KIRKLEES METROPOLITAN COUNCIL INVESTMENT & REGENERATION SERVICE

DELEGATED DECISION TO DETERMINE PLANNING APPLICATIONS

Reference No:	2026/62/90484/E
Site Address:	143, Church Lane, Gomersal, Cleckheaton, BD19 4QN
Description:	Change of use from dwelling to C2 for 4 children, erection of first floor extension and front porch, internal and external alterations
Recommending Officer:	Jennifer Booth

DECISION – Refused

Proposed Plans & Elevations

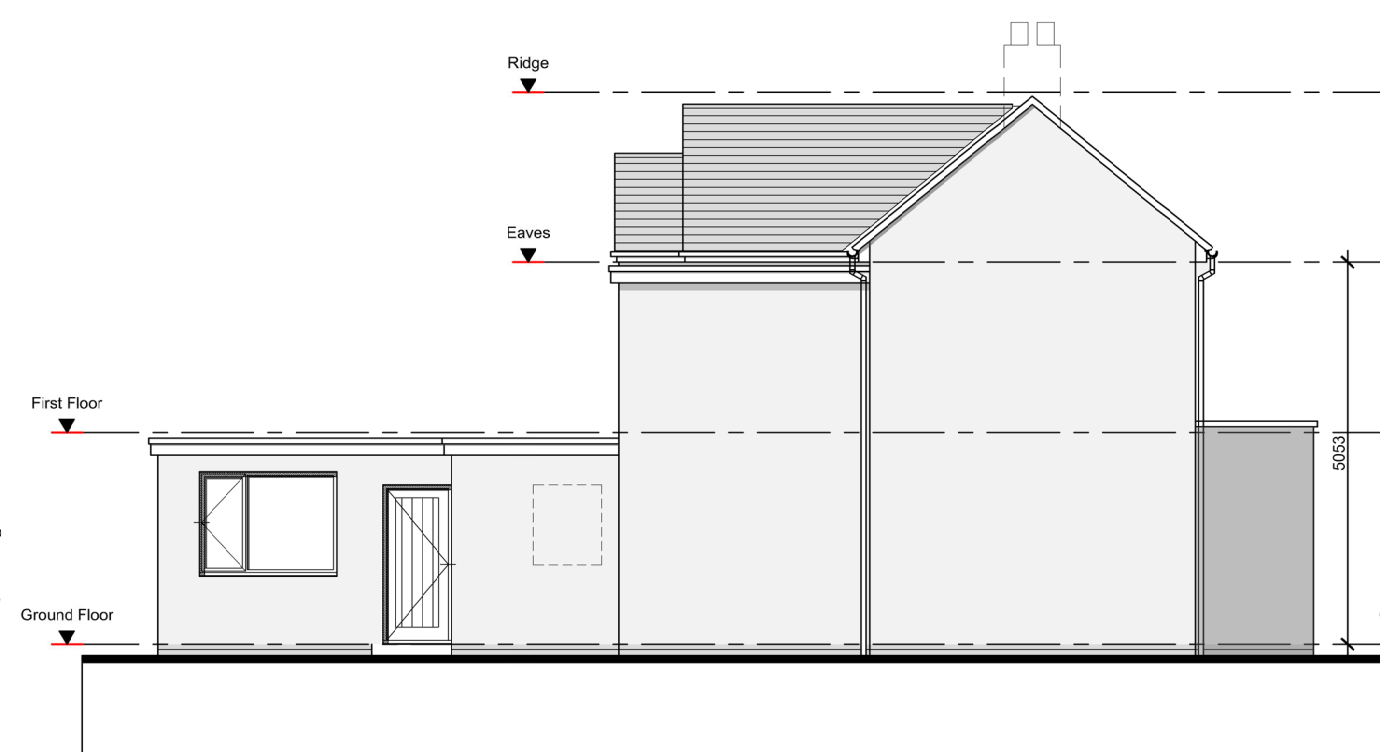
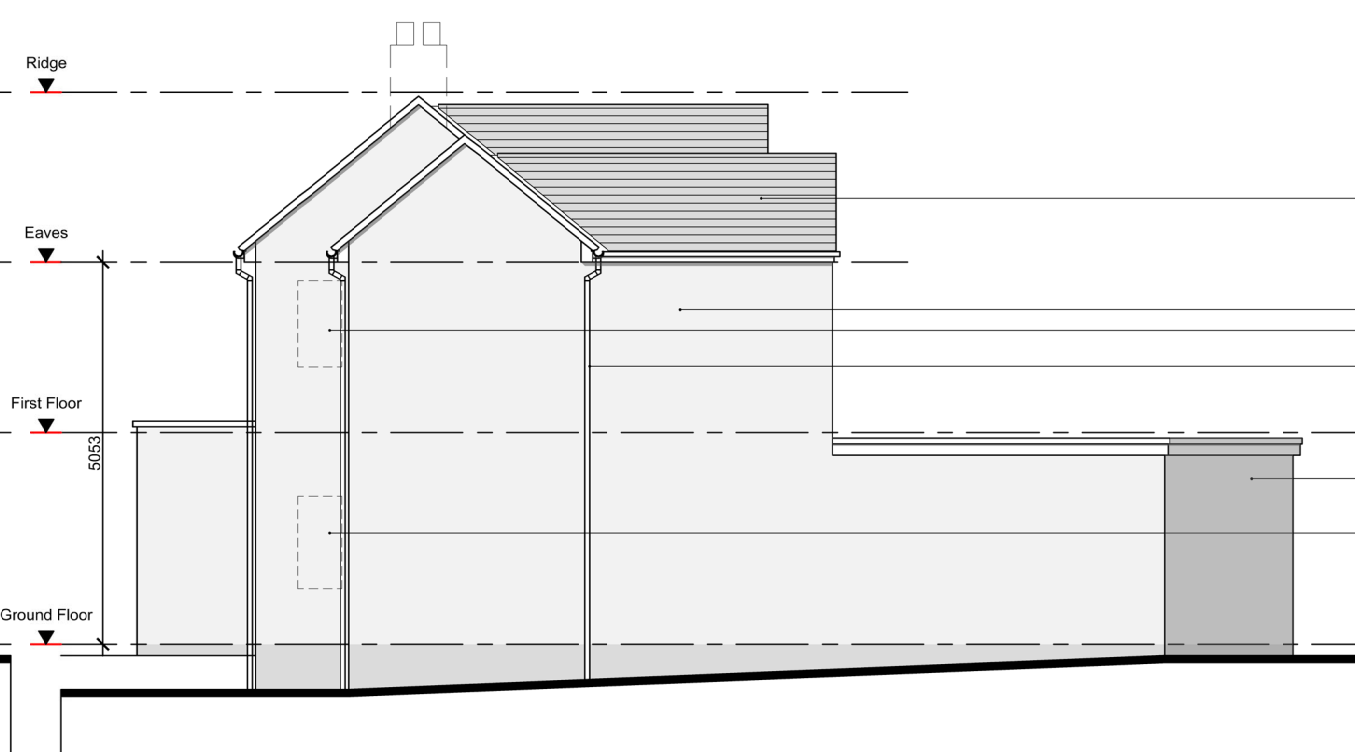
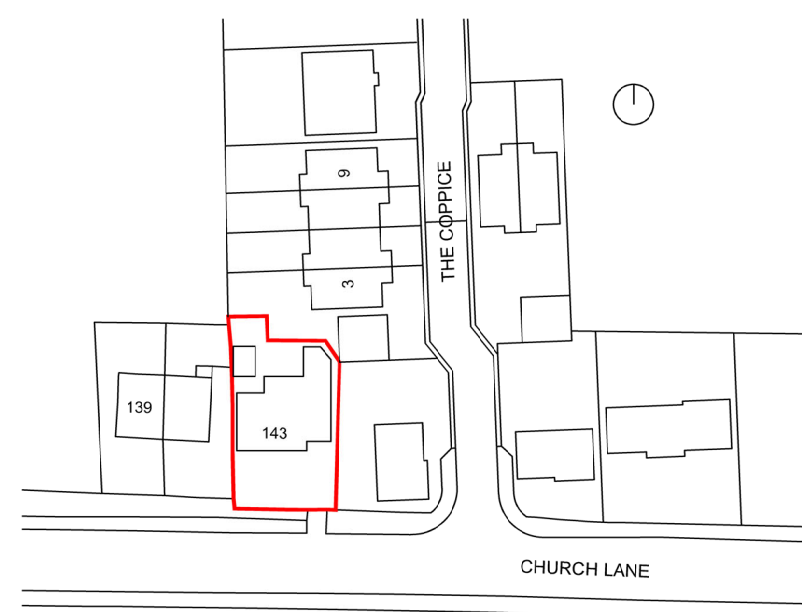
Members considered that the scale and height of the proposed first floor side extension would result in an overly dominant form of development within the street scene. It was considered that the extension would appear excessively prominent and would not relate satisfactorily to the character and appearance of the surrounding properties, resulting in an overbearing presence when viewed from the public realm.

Members expressed concerns that the scale and height of the first floor side extension would have an overbearing impact on the occupiers of neighbouring properties, particularly 1 The Coppice and 3 The Coppice. Members considered that the increased bulk and massing of the extension would adversely affect the outlook enjoyed by these neighbouring residents.

Members were not satisfied that the proposed first floor extension would adequately safeguard the privacy of neighbouring occupiers. Concerns were raised that the development would introduce opportunities for overlooking towards the residential properties and private amenity spaces at 1 The Coppice and 3 The Coppice, resulting in an unacceptable loss of privacy.

1. The proposed first floor side extension, by reason of its scale, height and massing, would result in a dominant and overbearing addition that would appear incongruous within the street scene. The development would fail to reflect the character and appearance of the host dwelling and surrounding development, causing harm to the visual amenities of the area and would therefore be contrary to Policy LP24 of the Kirklees Local Plan and Chapter 12 of the National Planning Policy Framework.

2. The proposed first floor side extension, by reason of its scale, height, bulk and proximity to neighbouring properties, would have an unacceptable overbearing impact on the occupiers of No. 1 The Coppice and No. 3 The Coppice. The proposal would result in an undue sense of enclosure and harm to the living conditions of neighbouring residents, contrary to Policy LP24 of the Kirklees Local Plan and Chapter 12 of the National Planning Policy Framework.

3. The proposed first floor side extension would introduce opportunities for overlooking towards the neighbouring residential properties at No. 1 The Coppice and No. 3 The Coppice. Members were not satisfied that the proposal would adequately protect the privacy of adjacent occupiers and considered that the development would result in an unacceptable loss of privacy, contrary to Policy LP24 of the Kirklees Local Plan and Chapter 12 of the National Planning Policy Framework.

Proposed Site Layout 1:100

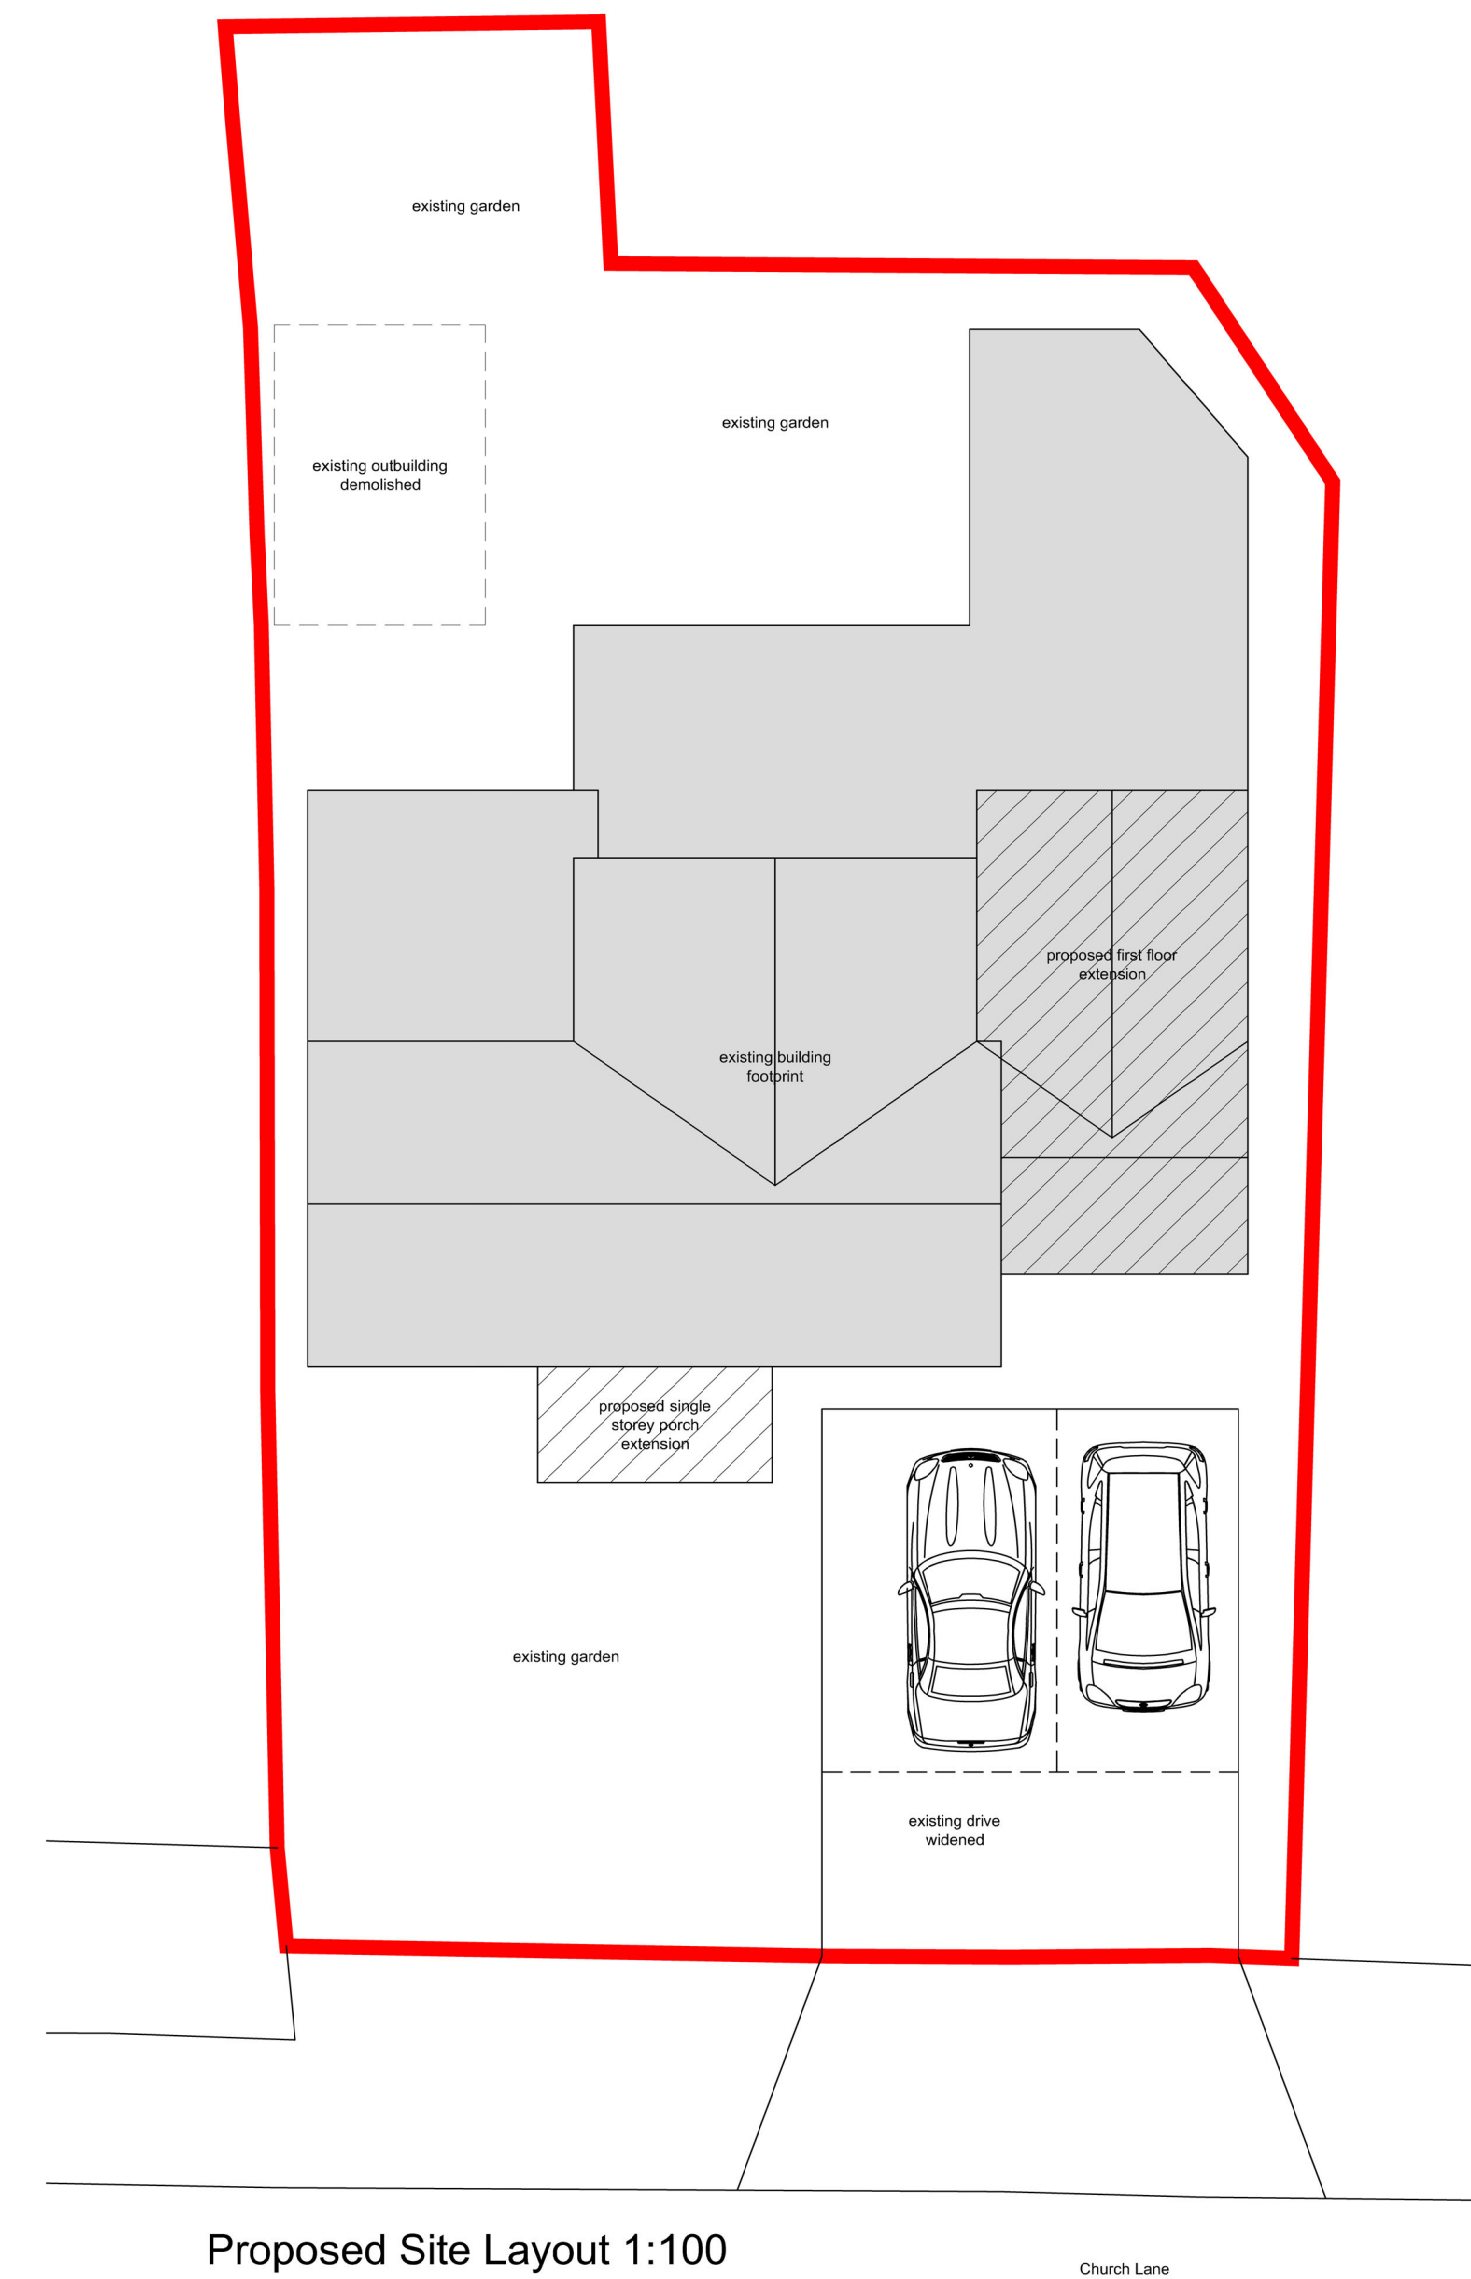
Members were unconvinced that the proposed parking arrangements would be sufficient to support the use of the property as a children's home accommodating four children. In particular, concerns were raised that the provision of two off-street parking spaces, together with limited on-street parking availability within the locality, would be inadequate to accommodate staff, visitors and operational requirements associated with the use. Members therefore considered that the proposal could result in increased parking pressures within the surrounding area.

4. Insufficient information has been submitted to evidence that the proposed parking provision of two off-street parking spaces would be sufficient to serve the operational requirements of a

children's home accommodating four children. Having regard to staffing requirements, visitors to the site and the limited opportunities for on-street parking within the surrounding area, the proposal would be likely to result in increased on-street parking demand to the detriment of highway safety and the convenience of existing residents. The proposal is therefore contrary to the parking and highway safety objectives of Policies LP21 & LP22 of the Kirklees Local Plan.
